Listed building consent for a two storey extension, single storey rear extension and external staircase.

Mews House London Road Arundel

Application ref: AB/15/19/L

MPS		PROPOSED ELEVATIONS AND SECTIONS	14/01/19	A
DRAWN	CHECKED		DATE	REV

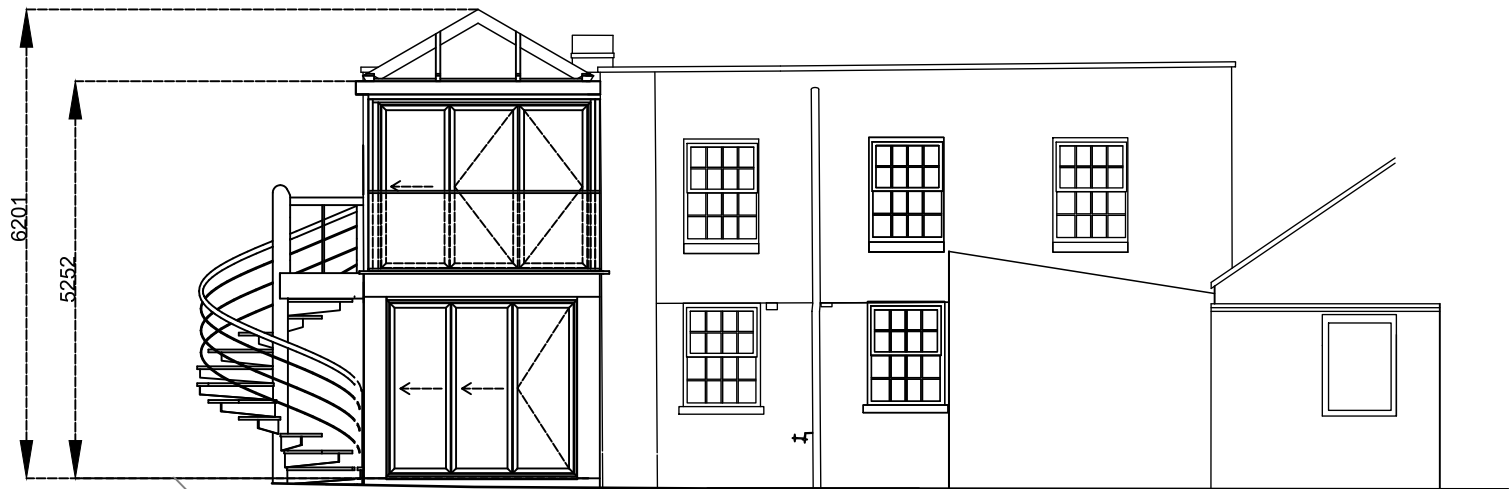
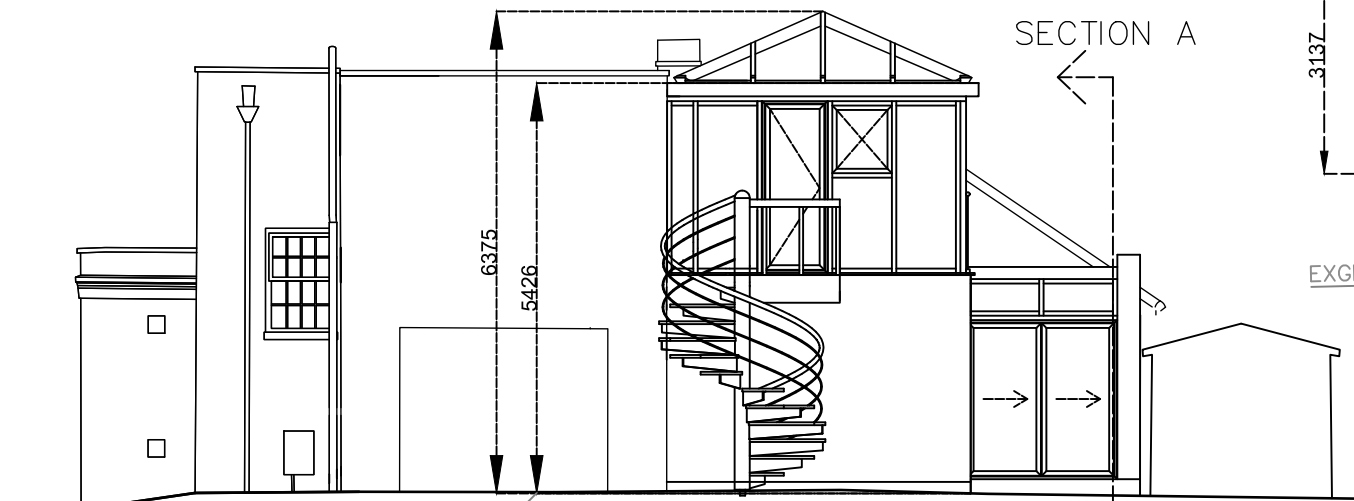
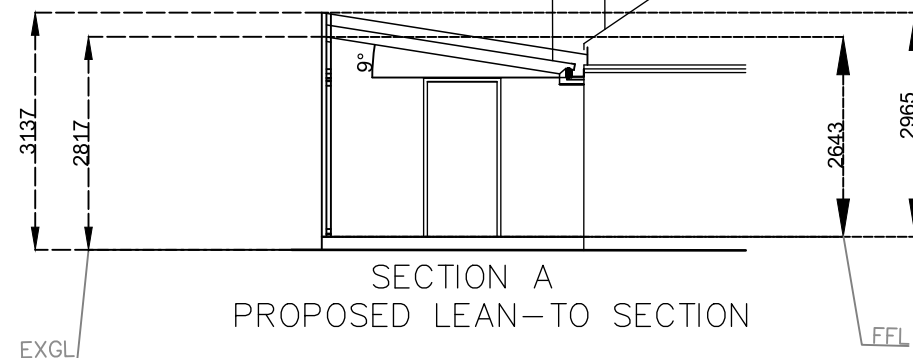
Due to its location and design, the proposed development, if allowed to proceed, will be a most unattractive feature in Arundel and London Road and its environs in particular. The proposed build is not of traditional design. It is not in keeping with the existing adjacent buildings i.e. St Wilfrid's Priory, the Parish Church of St Nicholas and the Cathedral of Our Lady and St Philip Howard. It neither preserves nor enhances the character of the Conservation Area.

The proposal, because of its siting, scale and height would affect adversely the visual amenities of the area. The extension is on the southwest corner of the house and the front west side of the sunroom, with its door and its prominent external staircase, would inevitably be clearly visible from London Road. While I appreciate that conservatories are permitted development at ground level, this proposal constitutes a conservatory at FIRST floor level which would be an inappropriate and dominant feature in a conservation area.
